Demolition of existing building & construction of 2-bedroom bungalow with associated parking & landscaping (resubmission following A/146/19/PL). This application affects a Public Right of Way.

Land to the Rear of 1 The Heathers Arundel Road Angmering

Thank you for your internet representation made on 30th March 2020 which has been recorded as '**an objection**' with the comments as follows:

Proposed Bungalow Plans and Elevations

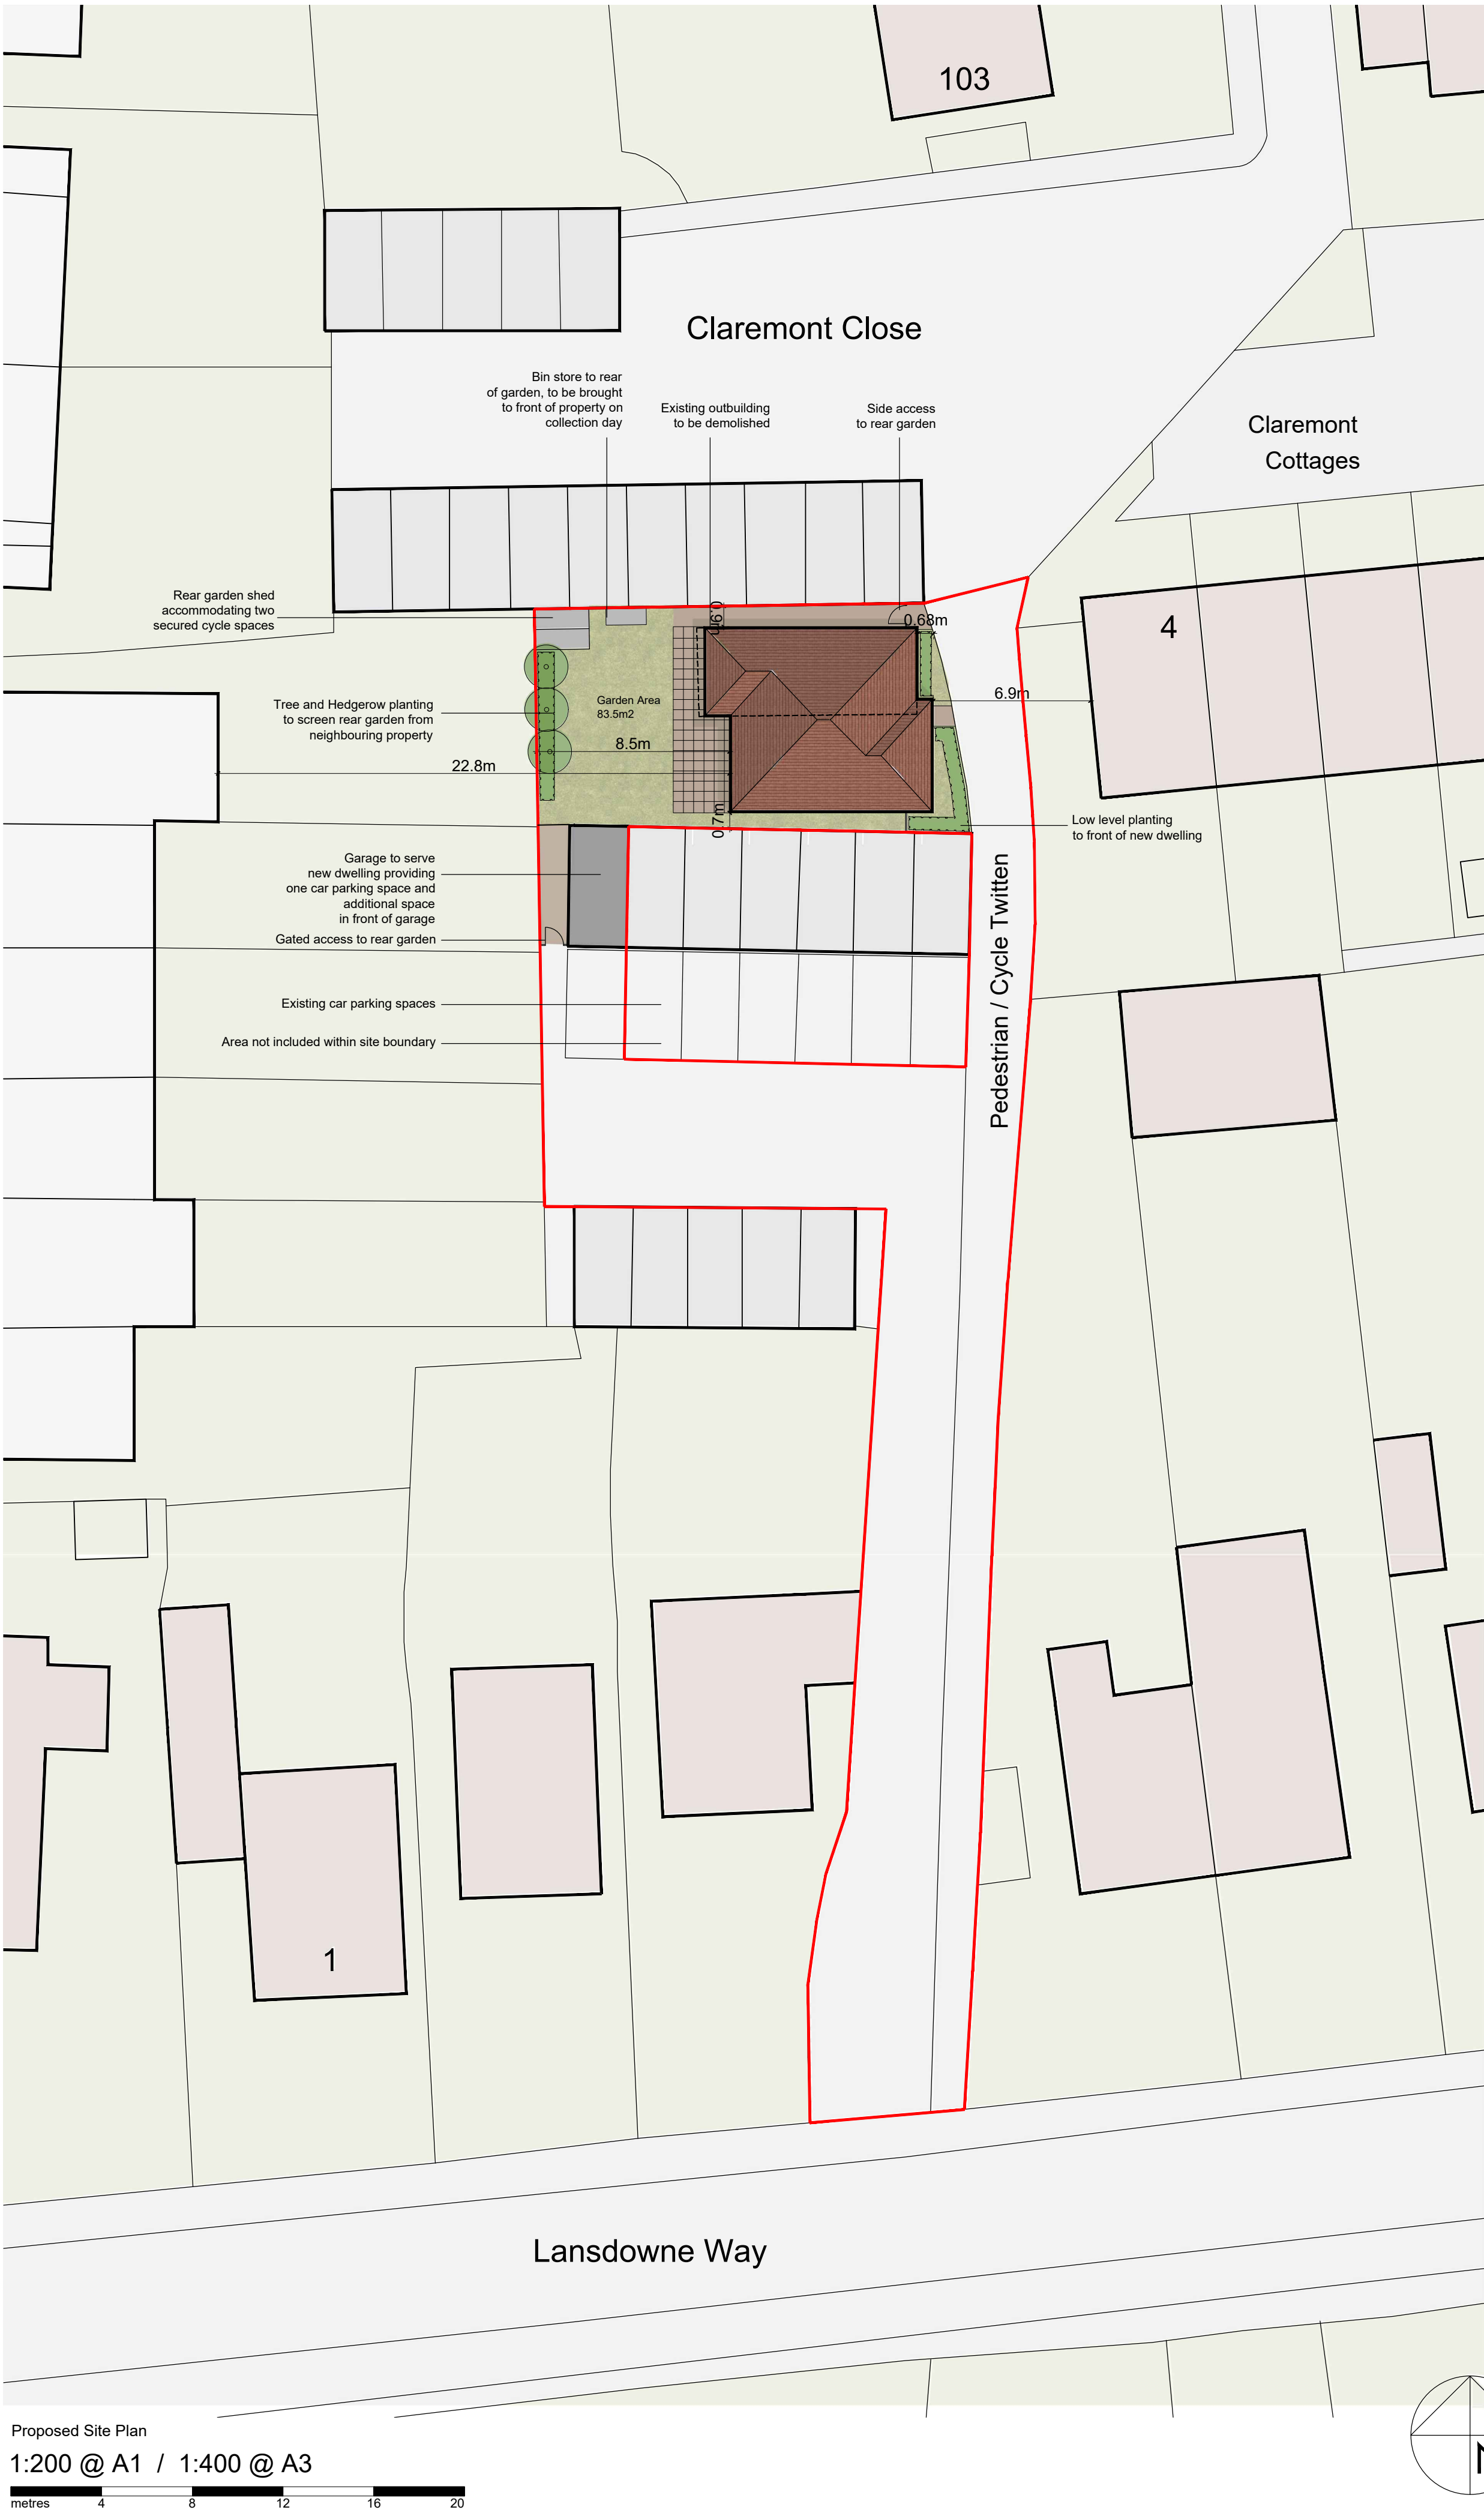
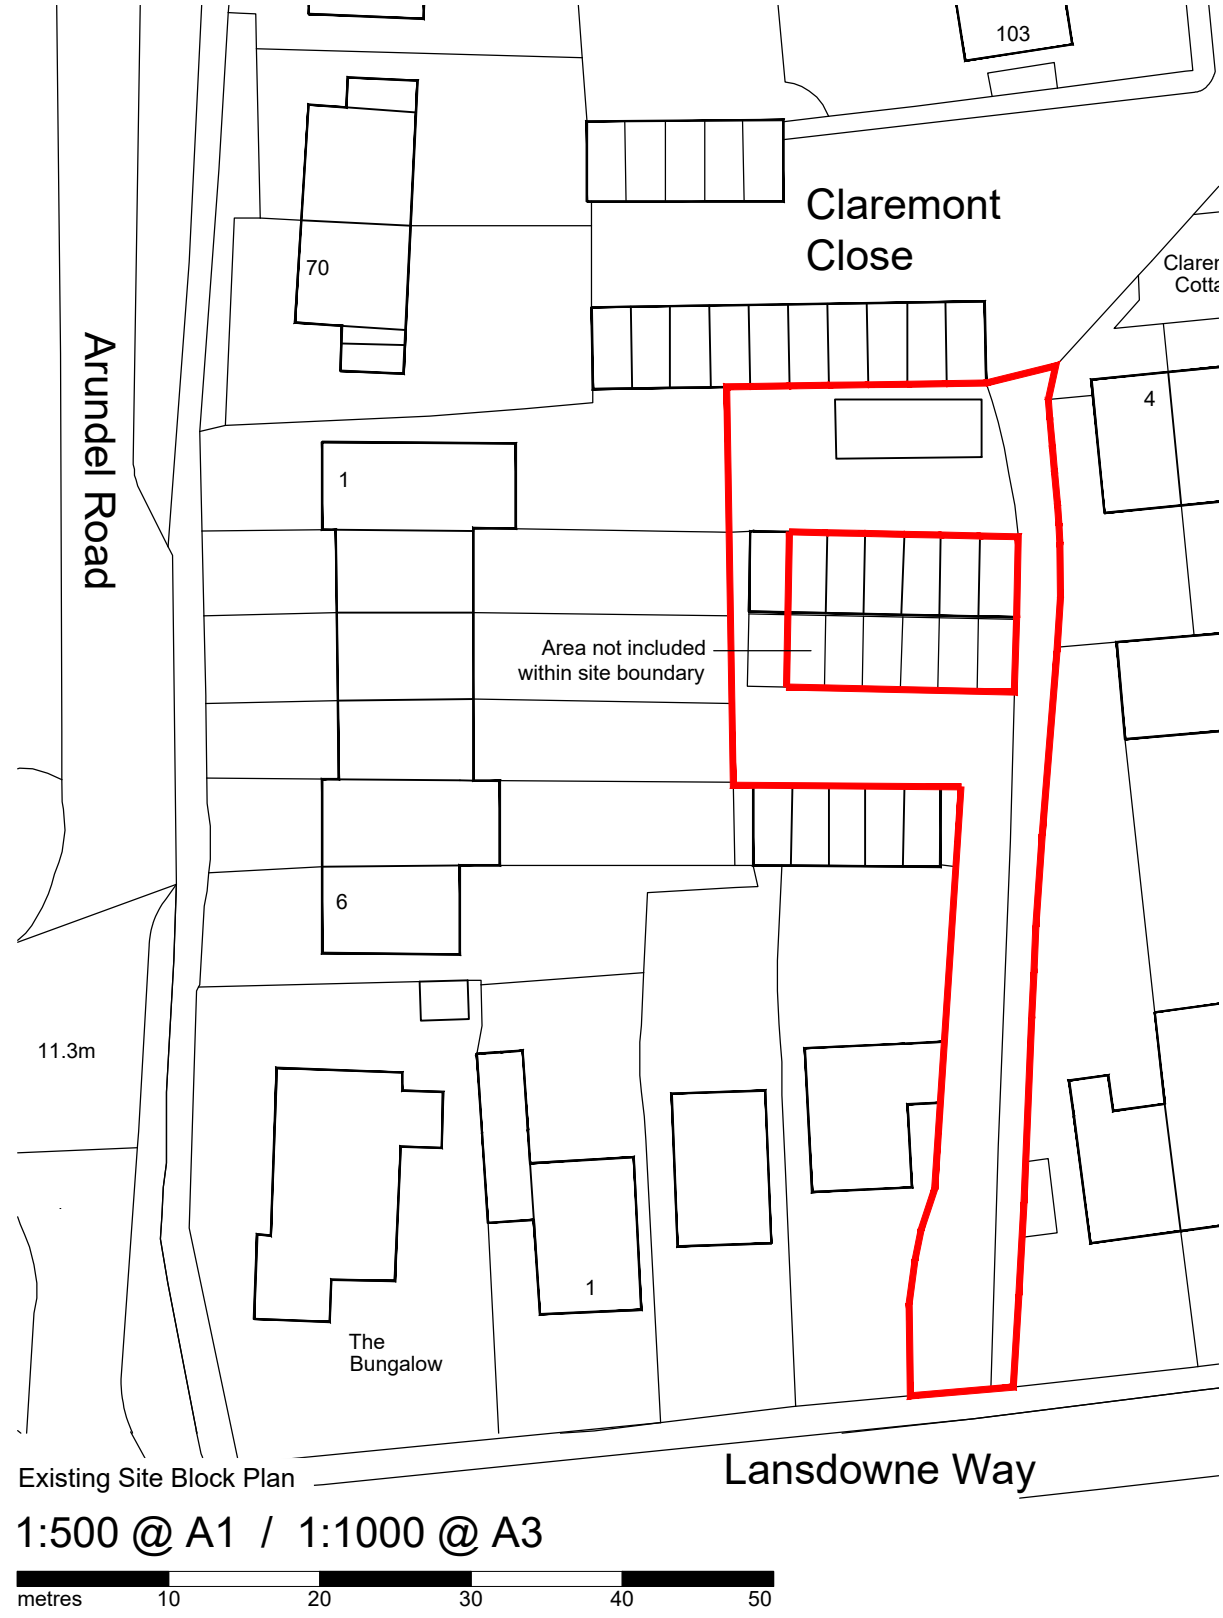
The floor to ceiling glazing on the east elevation may overlook habitable rooms along existing properties in Arundel Road (in particular no. 70, to 1-6 The Heathers). This design of glazing is not a sensitive response to existing properties and from our first floor windows we will be able to see into the proposed bungalow's living room and bedroom.
